D2016/4188

**Proposed Warehouse and Logistics Hub 585-649 Mamre Road, Orchard Hills (Penrith LGA)
– SSD 7173**

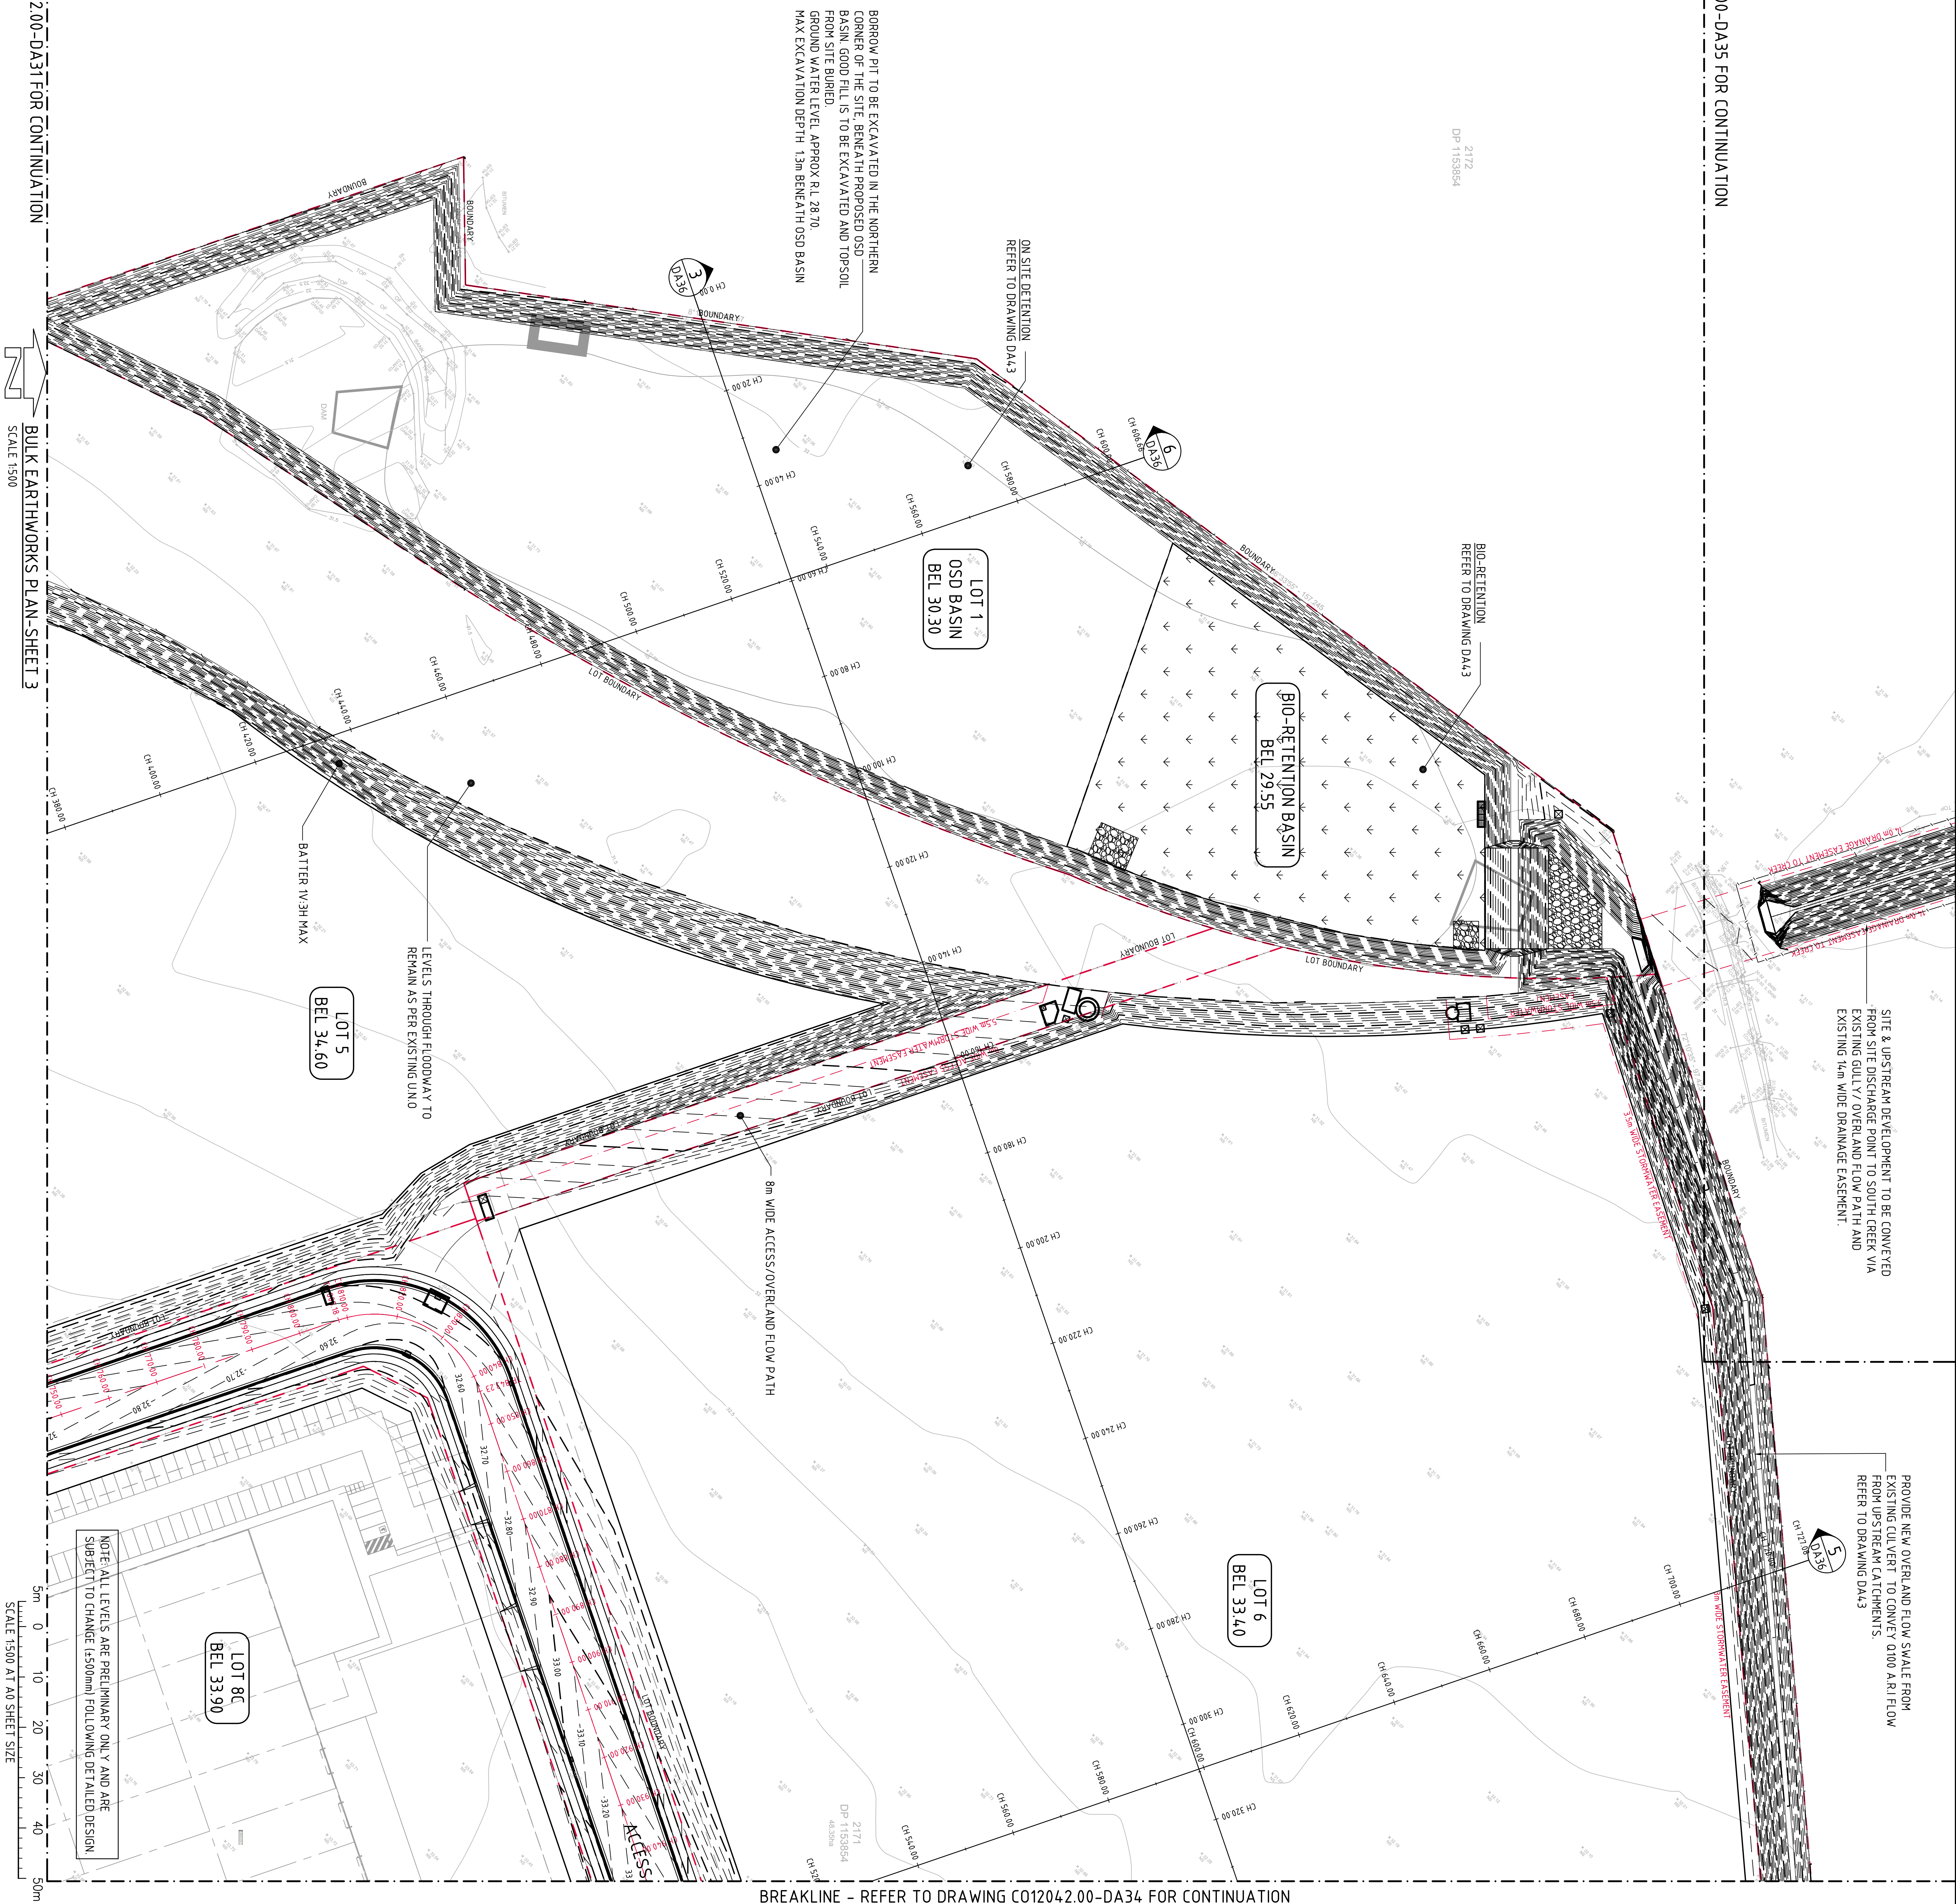
The southwestern corner of the proposed development described as Block 4 is shown in the bulk earthworks cut and fill plan (Drawing: C012042.00-DA30 Bulk Earthworks Cut/Fill Plan) as being subject to a borrow pit. WaterNSW notes that this area was originally excluded from development as a result of flood concerns, and is currently used to convey stormwater from the Pipeline corridor. WaterNSW requires that the flow of stormwater from the Pipeline corridor must not be impeded or caused to flow back to the corridor.

The proposed development includes earthworks that will result in an elevated batter along the boundary between the Pipeline corridor and the proposed development. The Pipeline corridor contains a raised berm that acts to direct stormwater from the subject site away from the corridor to existing drainage depressions. It is understood that the outcome of the flood studies was to require a portion of the land proposed for rezoning and development, specifically in Block 4, to be left undeveloped for flood management purposes. However, as the Pipeline corridor is not included in these assessments it is not clear what the impact of the development is on flood regimes. WaterNSW requests the consideration of the impact of the proposed development on flood regimes for the Pipeline corridor.

In addition it is understood that this same area is to be subject to works for the purposes of use as a borrow pit. As the construction of the borrow pit is not included in the flood assessment and the EIS and its associated documents do not contain information on the management or final plan for this area it is not clear what impact the proposed works may have on the flood regimes for the Pipeline corridor.
